Post Hearing Submissions and Response to Deadline 4 Submissions
ELMESTHORPE PARISH COUNCIL
9th February 2024

1. Introduction

Note: To be read in conjunction with the Access and Rights of Way Plans (document reference: APP-017 to APP-020) and the Public Right of Way Appraisal and Strategy (document reference: 6.2.11.2)

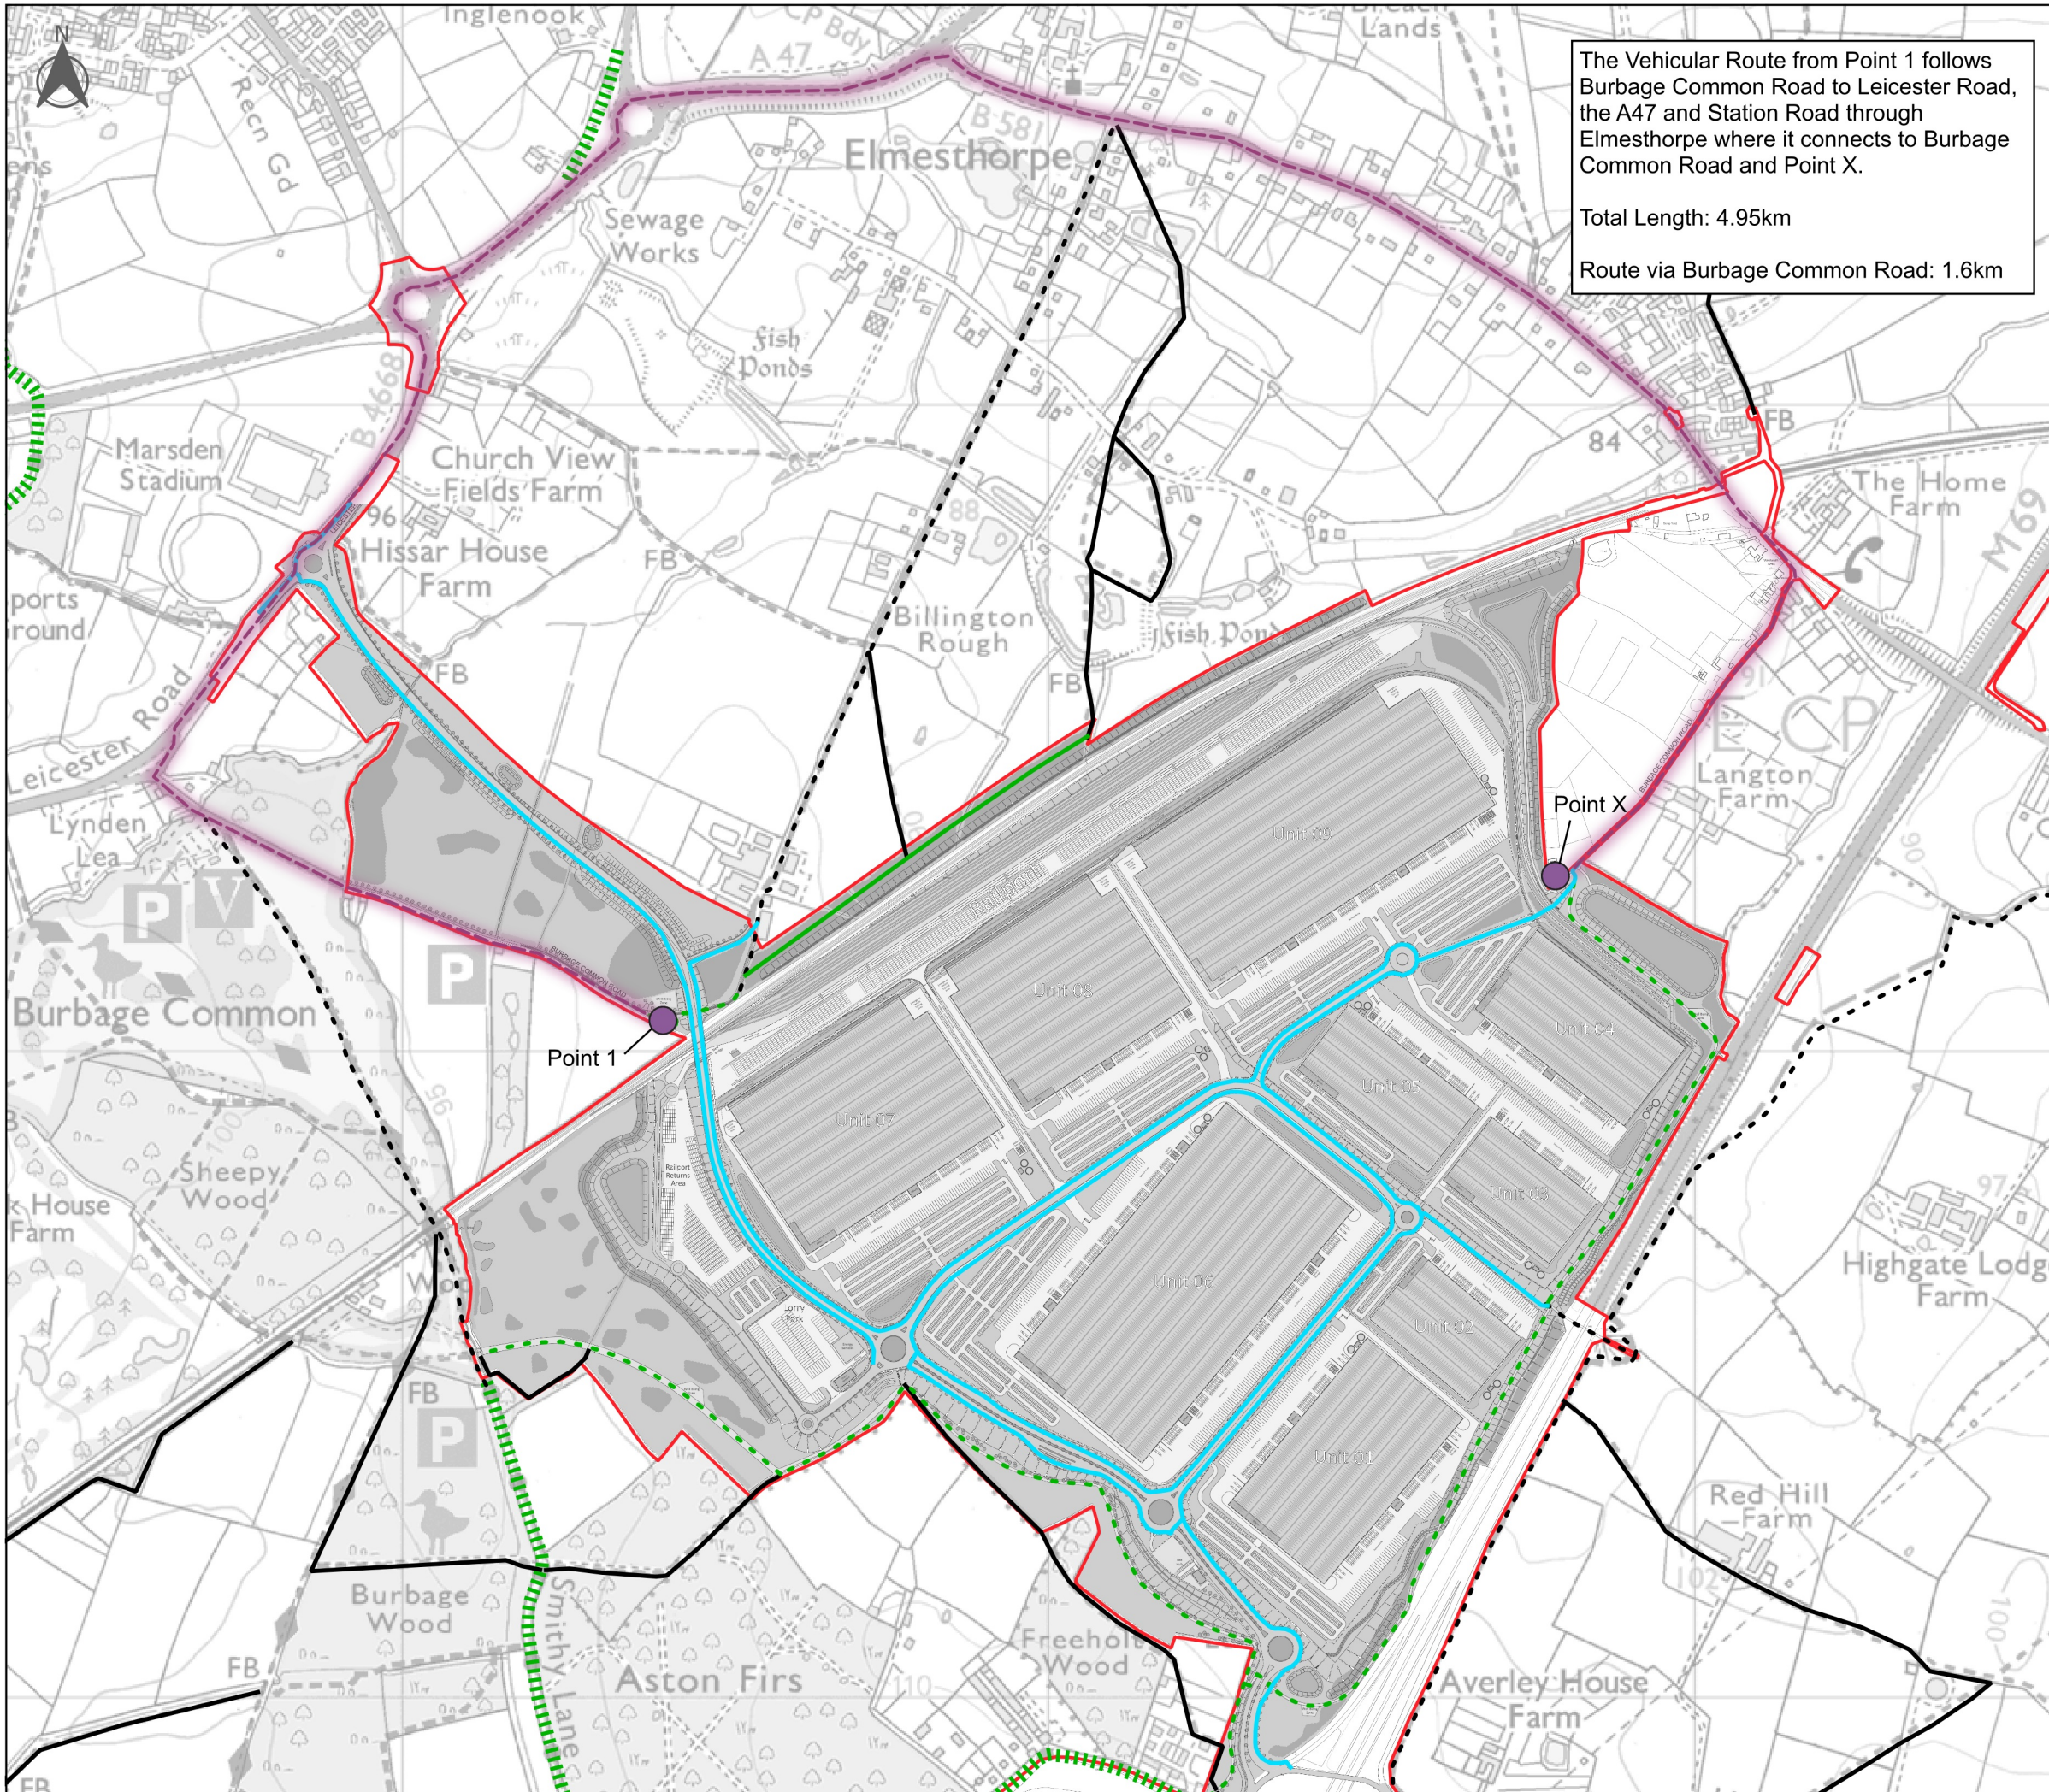
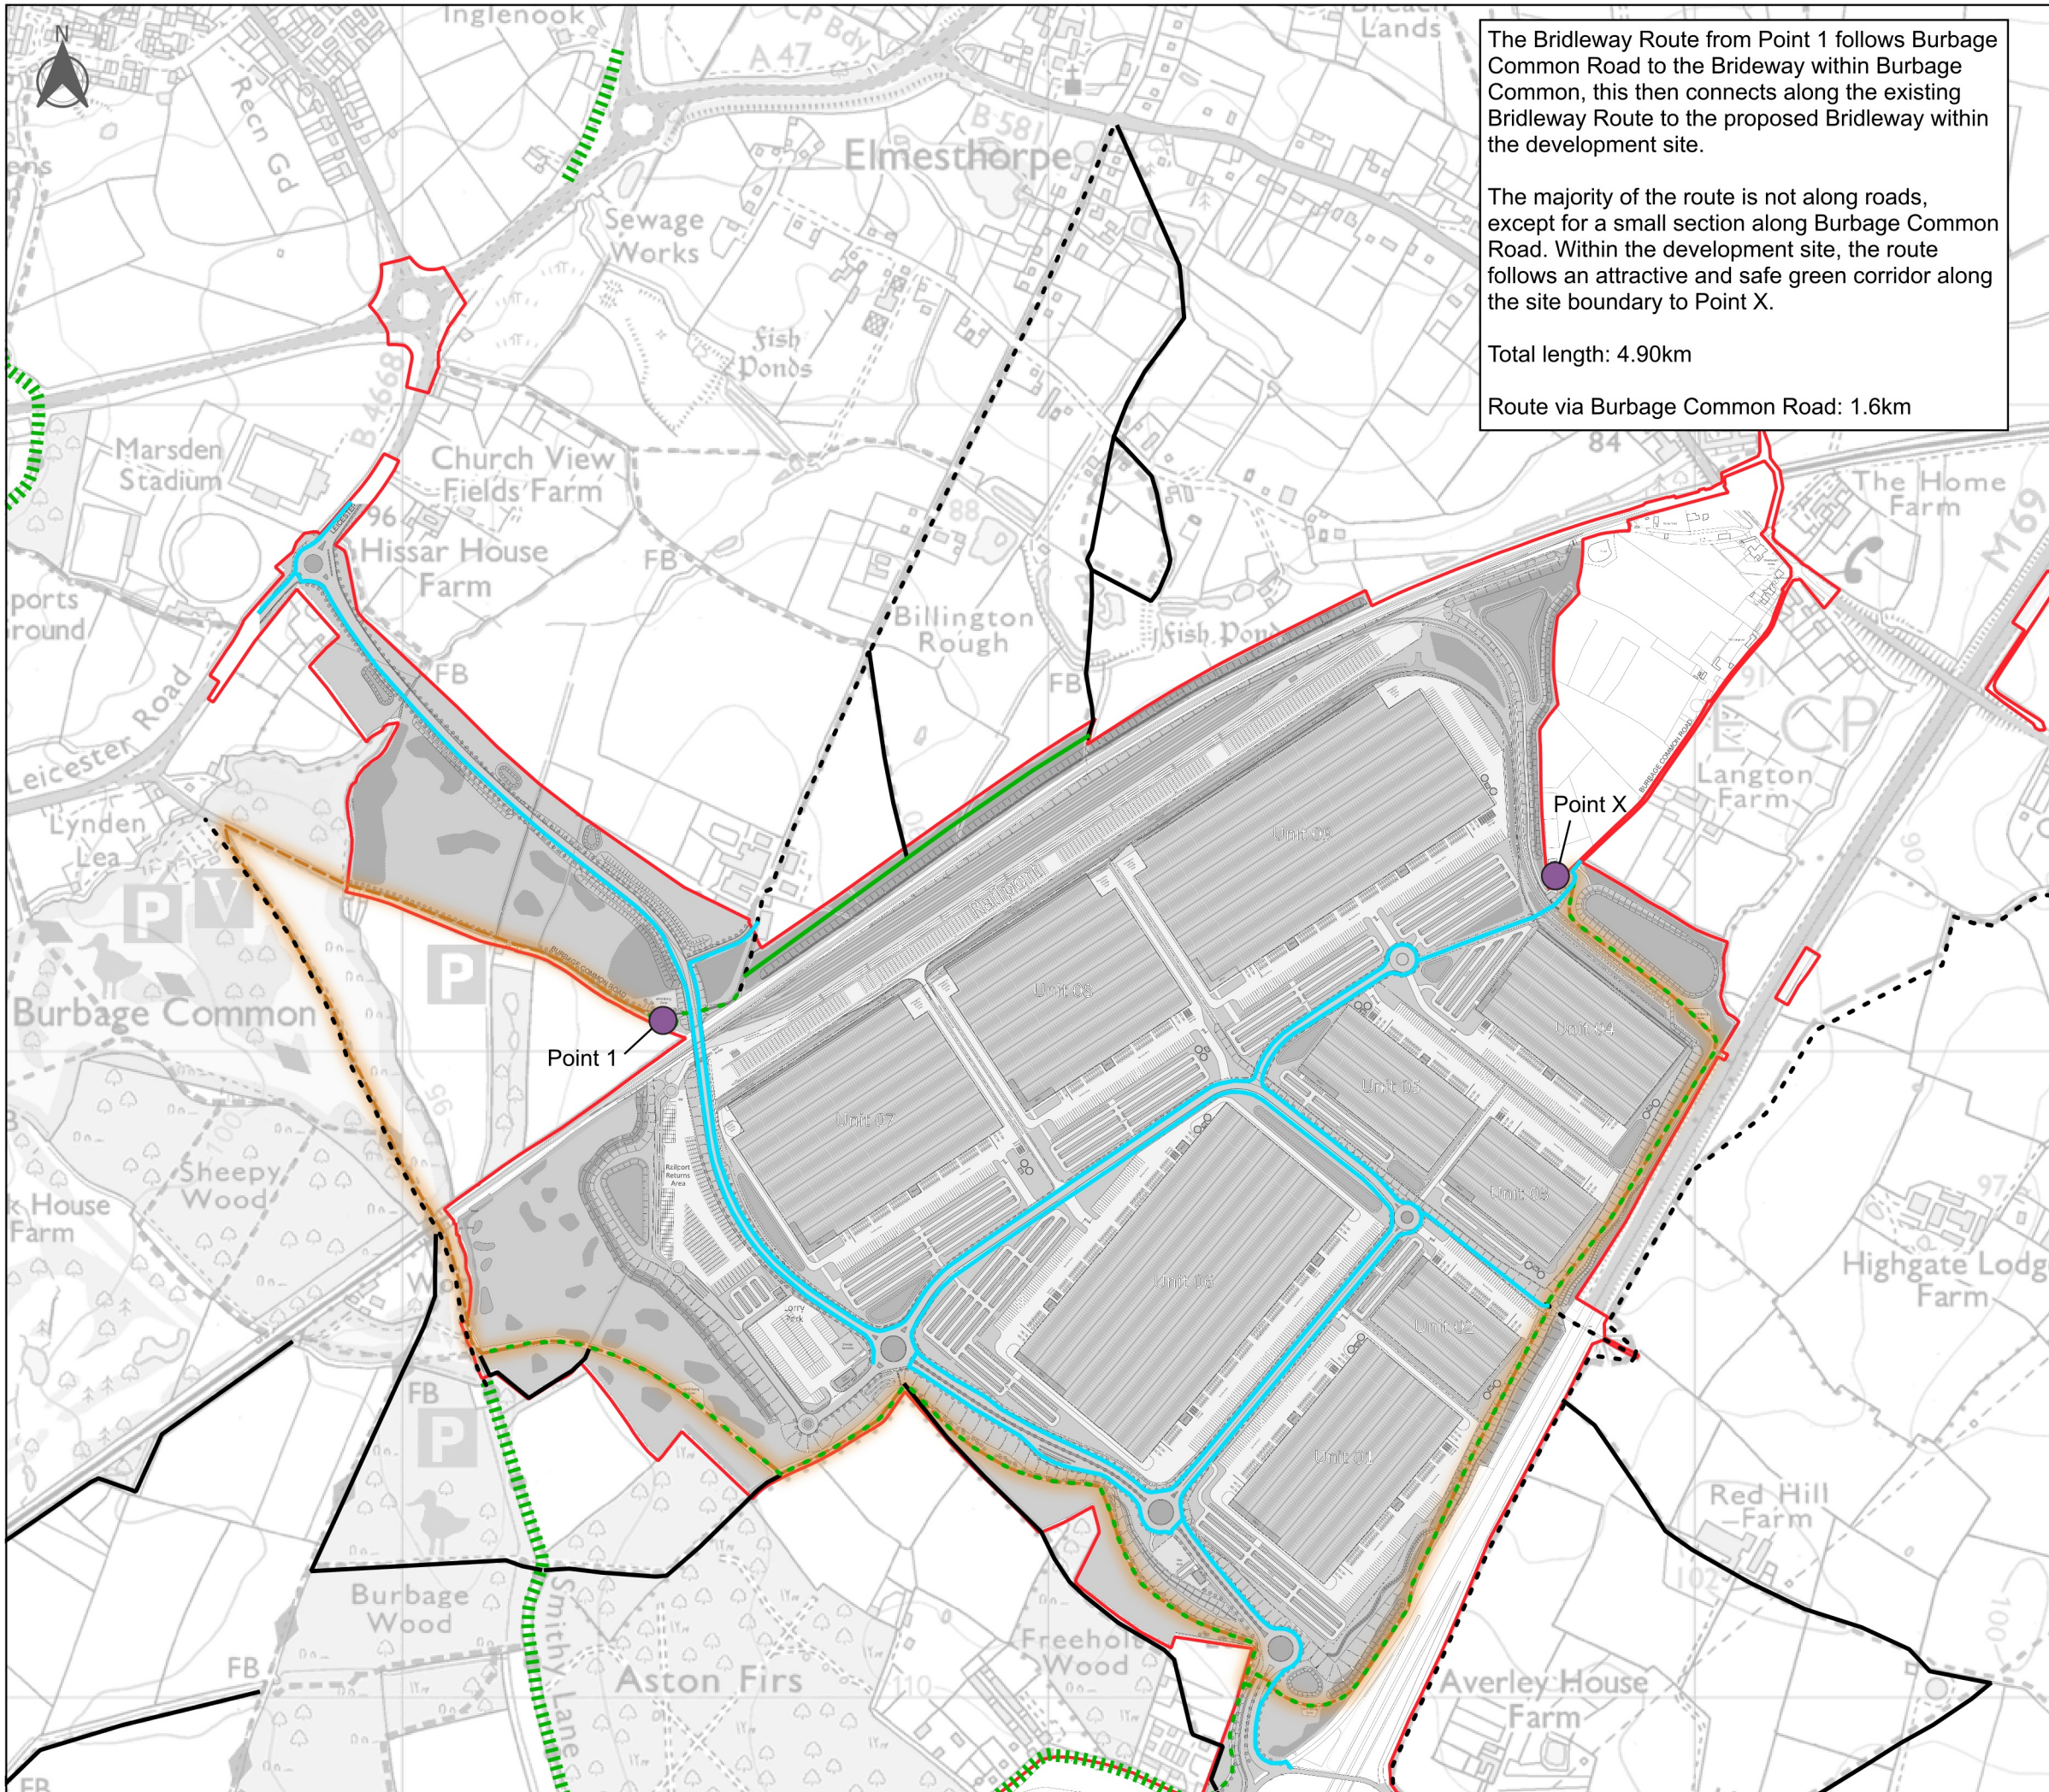
- 8.2. The Applicant has provided us with the details of the two alternative circular routes that will be available once the proposed RFI is completed. Please see appendix 3.

- 8.3. The first alternative circular route is 5.45miles/8.77km (incorrectly annotated as 8.74km on their map). This route travels mostly down the A47 link road and is an undesirable route. The increase to the existing route is +1.32miles/2.12km

- 8.4. The second alternative circular route is 6.35 miles long/10.2km. This route is more comparable with the amenity experienced with the current circular walk, and would be more desirable in terms of the surroundings within the limitations of the new surroundings. The increase to the existing route is +2.22miles/+3.57kms

9. The increase in the length of the alternative PRowS is really quite long, and for some, now too long. As well as the decrease in amenity value of our PRow, they are now more inaccessible to those with mobility issues, small children, poor health or simply just the time constraints of daily life.
